From: Rhodes, Kelly [REDACTED]
Sent: 20 June 2019 12:28
To: Planning.Responses
Subject: 52 High Street, Littlehampton, BN17 5SY.

PLAN-028278

Proposal: Change of use of ground floor from banking (A2 Financial & professional services) to retail (A1 Shops), permitted development to form 2 No. flats above plus 1 No. further flat & extension to form 1 No. two storey dwelling & ancillary alterations. Site: 52 High Street, Littlehampton, BN17 5SY. LU/154/19/PL

BASEMENT PLAN [NO CHANGE]

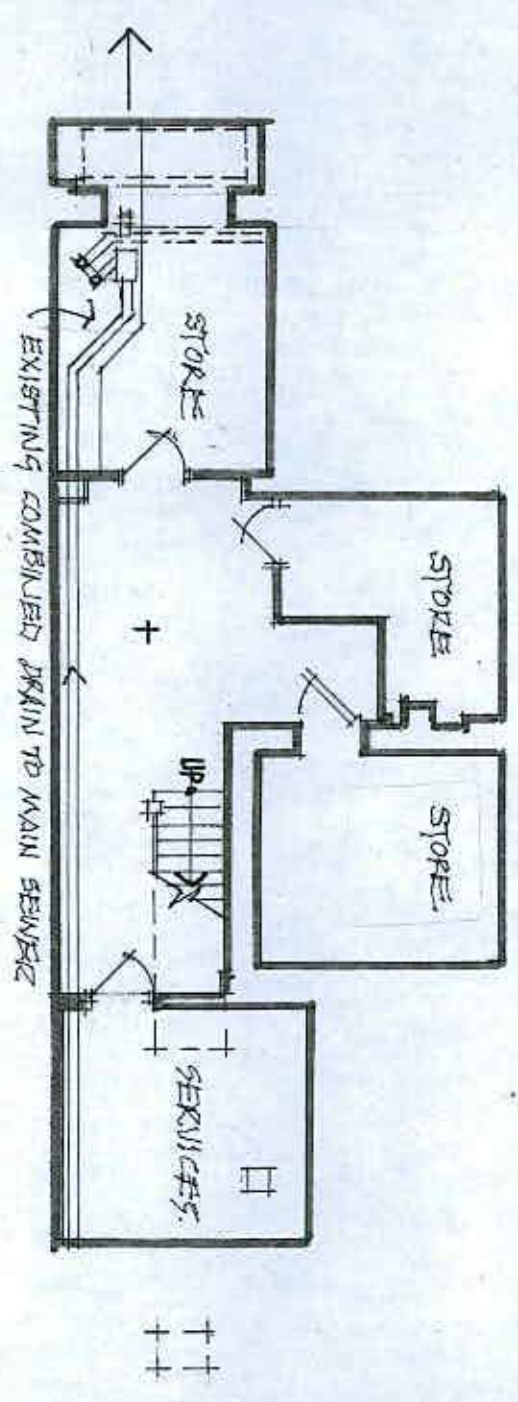
The detailed design for the proposed basement should take into account the possibility of the surcharging of the public sewers. We request that should this application receive planning approval, the following informative is attached to the consent:

"Detailed design of the proposed drainage system should take into account the possibility of surcharging within the public sewerage system in order to protect the development from potential flooding."
